STATEMENT OF COMMONALITY FOR STATEMENTS OF COMMON GROUND

HyNet Carbon Dioxide Pipeline

Document Reference Number D.7.2

Applicant: Liverpool Bay CCS Limited

DRAWING TITLE
**WORKS PLAN REGULATION 5(2)(i)
APPLICATION DOCUMENT
REFERENCE D.2.4
SHEET 19 OF 37**

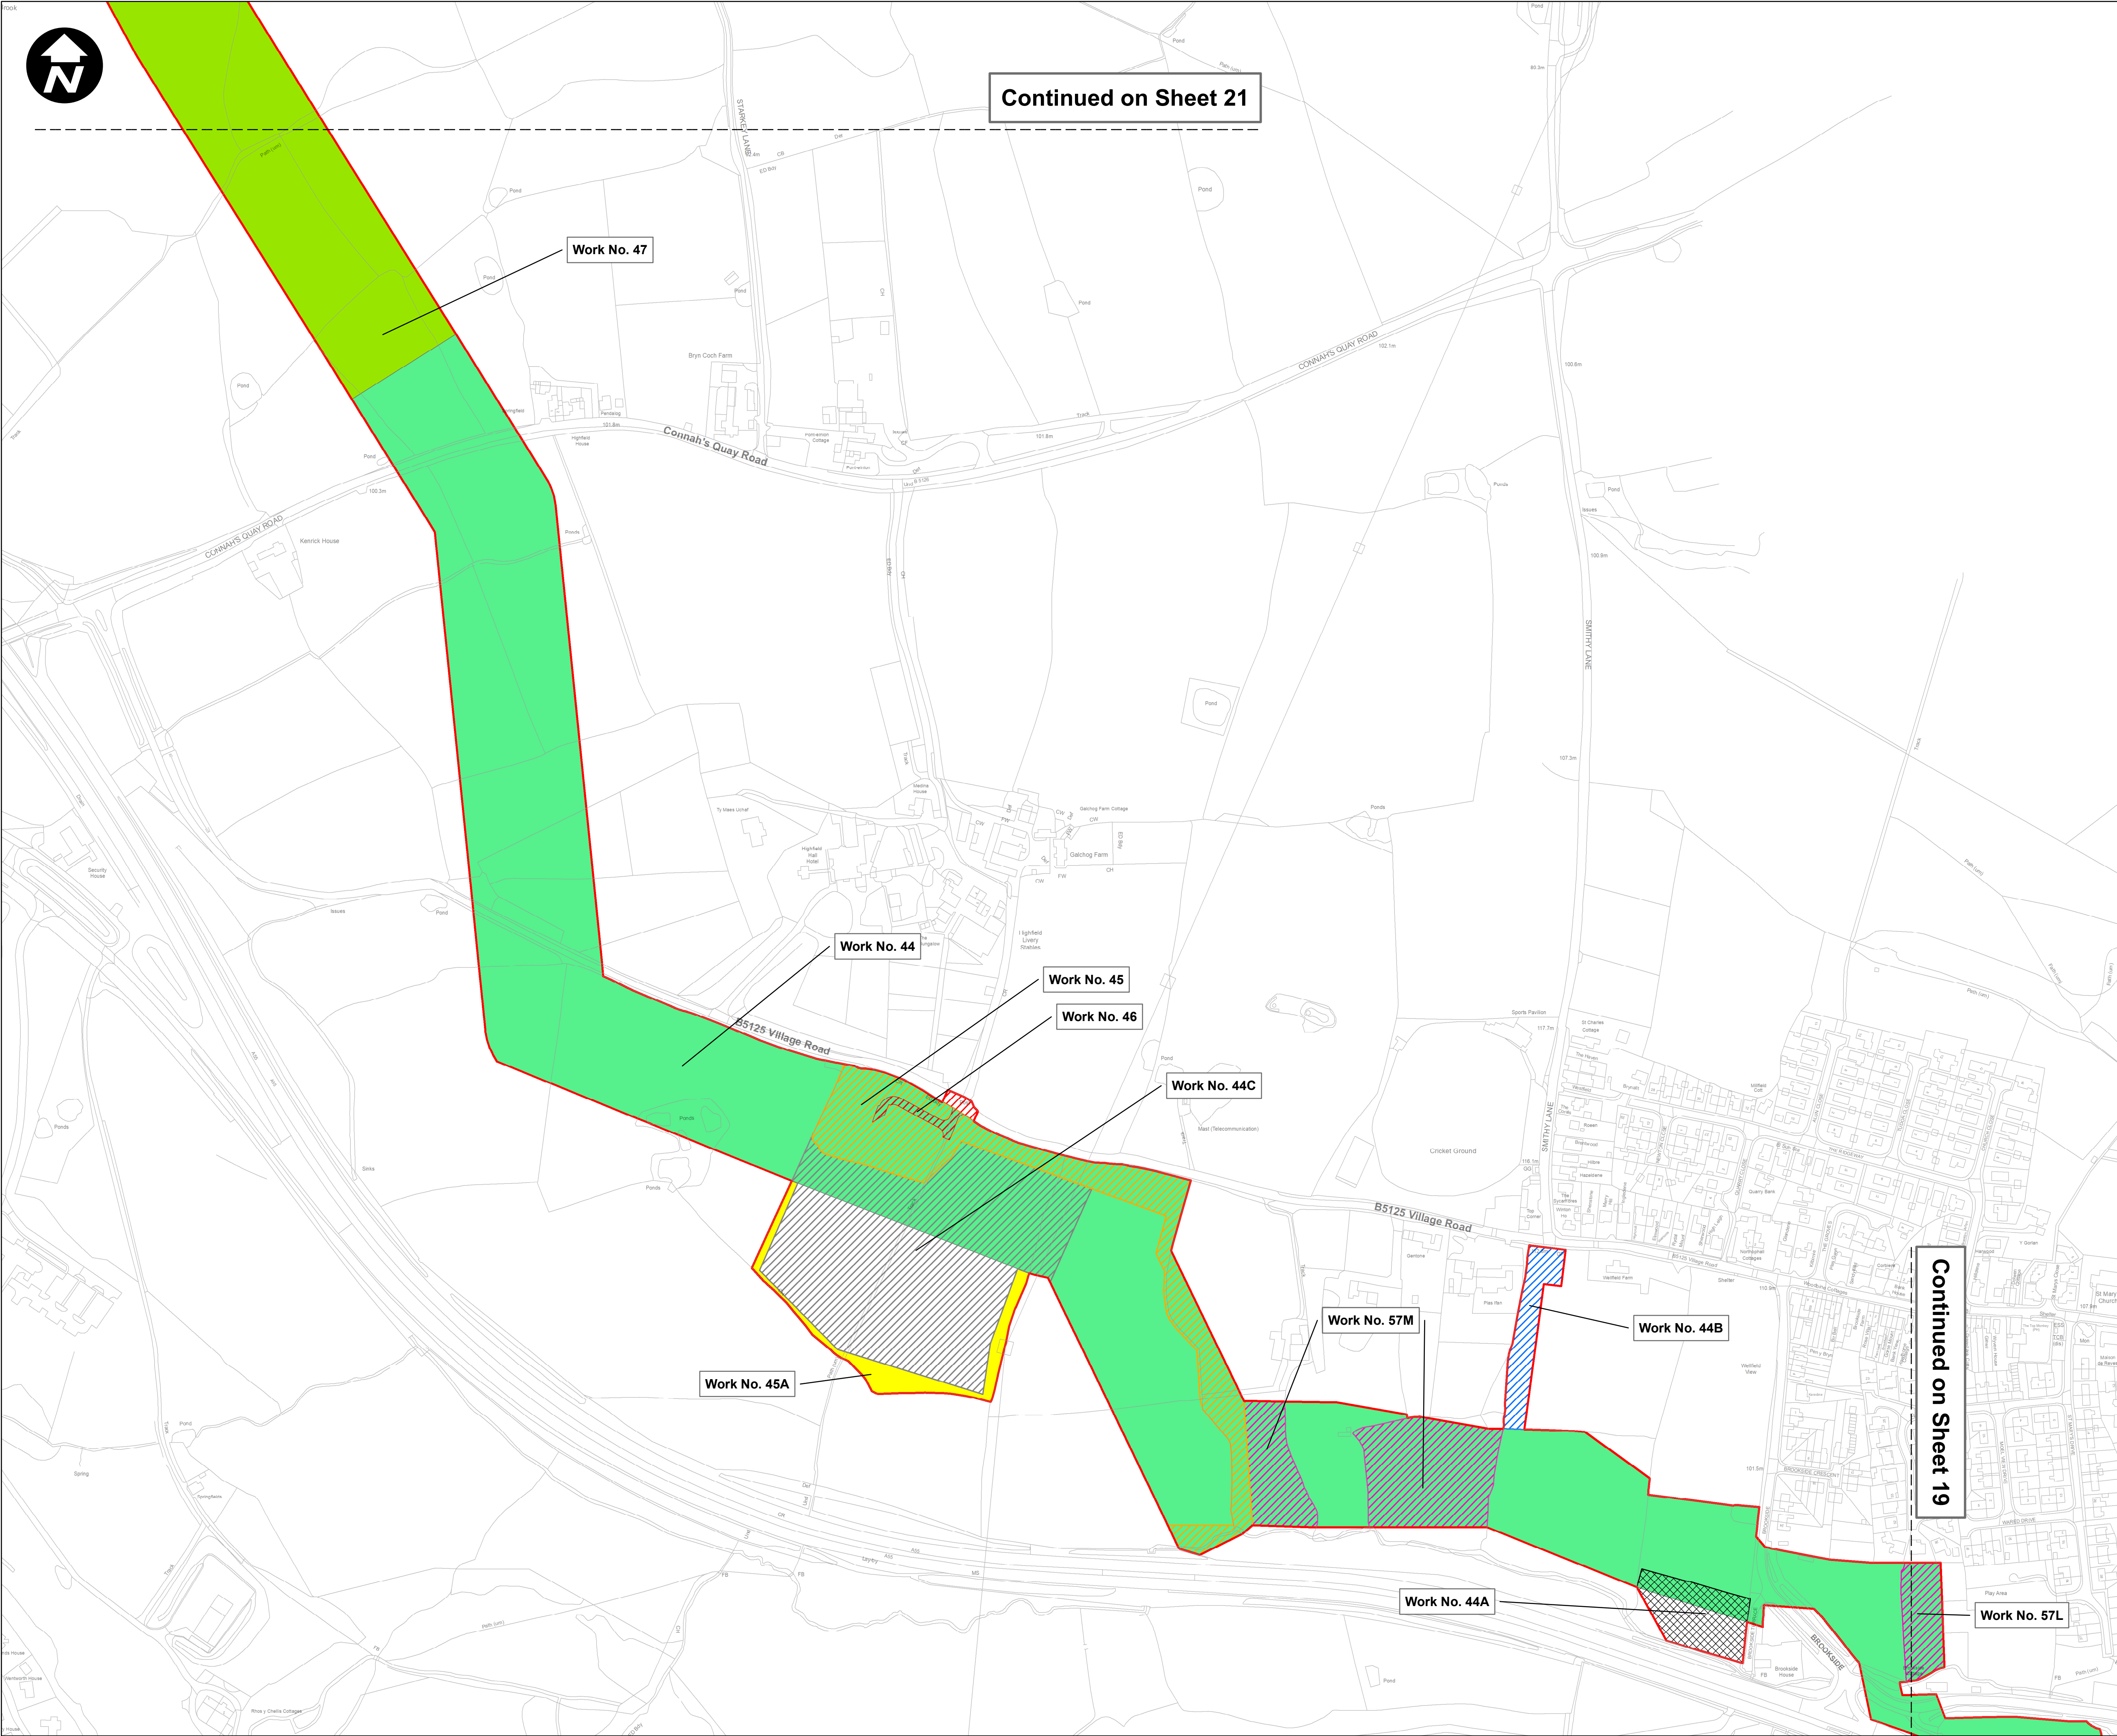
SHEET 19 of 37 - WORKS PLAN REGULATION 5(2)(i) APPLICATION DOCUMENT REFERENCE D.2.4 Specific area: Works No. 57K, 43B, 43A and 57J [Identified as Alltami Brook: Section 5.0 of the CMRA]

Our records indicate that there are six mine entries (three on-site mine adits CA ref: 327367-053, 327367-048 and 327367-049) and three off-site adits CA ref: 327366-235, 327366-235 and 327367-234); recorded shallow coal mining; and a coal seam of workable thickness outcrops at or close to the site that may also have been worked at shallow depths. These mining features are present within the area to the west and east of Pinfold Lane and north of Magazine Lane, Ewloe.

The CMRA identifies the two mine adits and comments that a geophysics survey was carried out to confirm the presence of these features. The report author states that no indication of the mine adits were found, although a potential void was located in the north eastern corner of the field. However it is noted that due to sight constraints, a full survey was not completed.

DRAWING NUMBER
EN070007-D.2.4-WP-Sheet 36

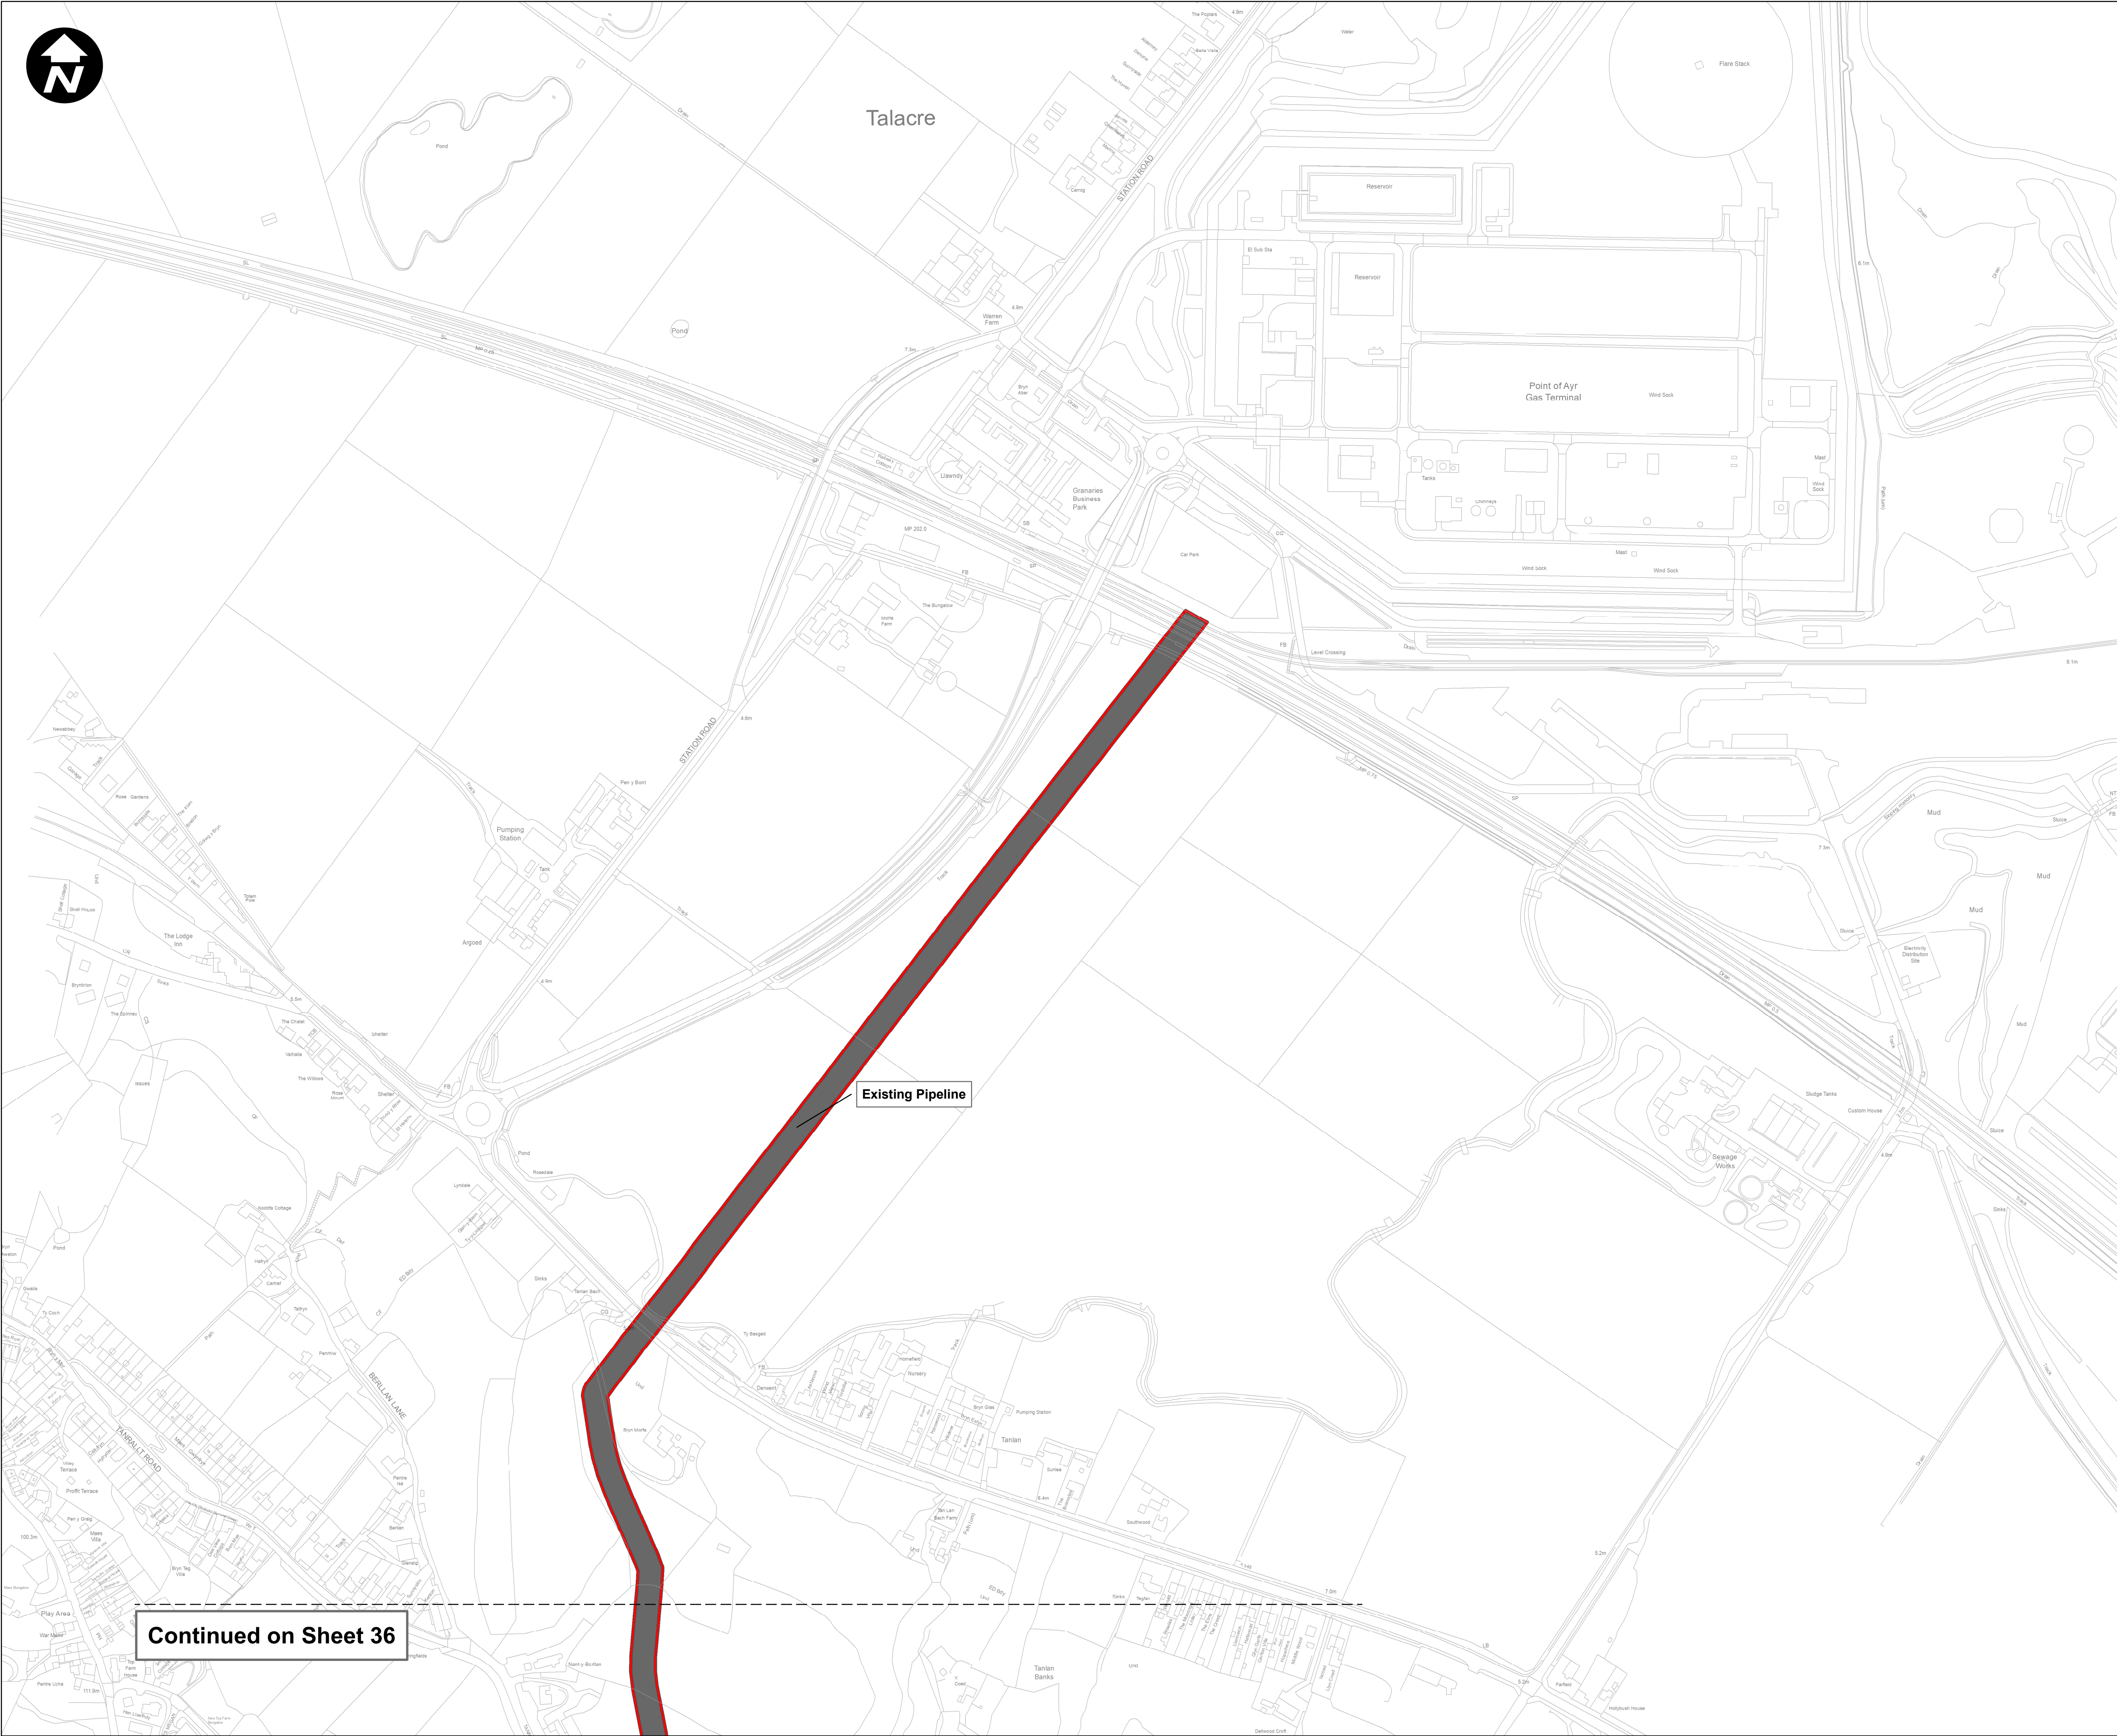
SHEET 36 and 37 of 37 - WORKS PLAN REGULATION 5(2)(i) APPLICATION DOCUMENT REFERENCE D.2.4 Specific area: Existing Pipeline[Identified as Point of Ayr Section 4.2 of the CMRA]

Our records indicate that the zone of influence of a recorded mine entry (CA shaft ref: 311382-011) extends into the red line boundary and the site lies within an area of probable shallow coal mine workings.

The CMRA states that the site does not lie within an area of probable historic unrecorded shallow coal mining however there are two recorded mine entries within the site. The Report makes reference to Coal Mining Report ref: 51002948750001, however I have not been able to find this specific Report in Appendix B. Nevertheless, it is acknowledged that this part of the project is the existing pipeline, which is to be decommissioned and then commissioned with a new plant (temporary storage compound). It therefore appears that no changes or new development is being proposed in this area.
